REVIEW of Environmental Impact Statement (EIS) for the proposed Hanson Construction Materials Pty Ltd Concrete Batching and Aggregate Handling Plant at Berth 1, Glebe Island

HANSON EIS REVIEW

Figure 16 Proposed layout of the Glebe Island Concrete Batching Plant

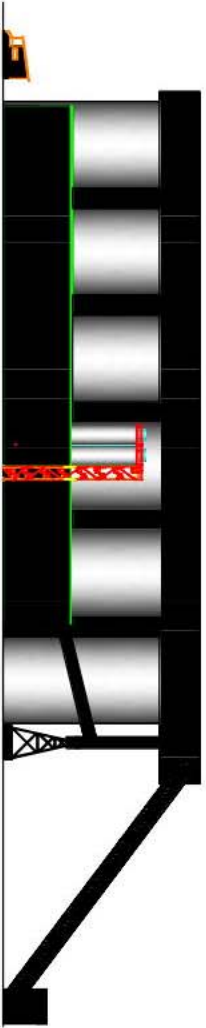
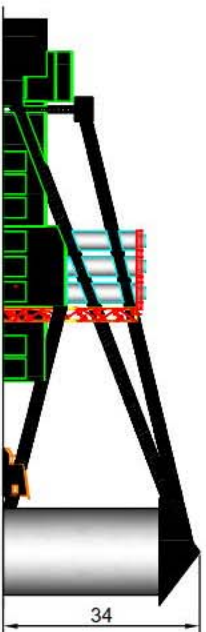
The proposed development occupies a site area of over 16,000sqm (approximately 21/2 football fields). The height of the main roof is unclear from the documentation but appears to be around 15m. There are two banks of silos, one (6 silos) being 25m high located in the centre of the building and the other (larger) row of 6 aggregate storage silos along the southern boundary.

This development would appear to most observers as a large-scale industrial building, completely lacking in aesthetic quality; inappropriately sited on the edge of Johnstons Bay and parked awkwardly alongside an existing heritage item; and the antithesis of good urban design. It would be a visual affront

The concrete batching plant has a maximum height of 25 metres and contains roofed silos which are 34 metres in height. It covers an area equivalent to 21/2 football fields. It is massive and completely out of scale in its context. Claims that this is “comparable” to scale, size and footprint permitted on site by the White Bay and Glebe island master Plan 2000 are disputed. Clearly, the proposal exceeds what is permitted in that Plan and attempts to “gloss over” this fact. The suggestion of mitigating physical height and scale is disingenuous. It is what it is -very large, over-scaled, out of context. Claims that the taller and more intrusive components will integrate with its setting and not appear visually prominent are plainly false.

*These appear to be deceptive statements attempting to convince people that the proposed concrete batching plant is other than it is – very large! 34-metre high silos **do not represent a low-profile design sympathetic to its surrounding environs**. 34 metres is the equivalent of an 11-storey building! To put this into perspective, Evolve (the apartment building directly opposite the proposed concrete plant) is 12-storeys in height. In fact, the scale of this proposal is so large that views of important heritage and iconic buildings such as the Glebe Island Silos and the Anzac bridge will be obliterated from many vantage points along the public parks and promenades alongside Johnstons Bay. The character of Glebe Island is low-profile. The character of the proposed facility is not.*
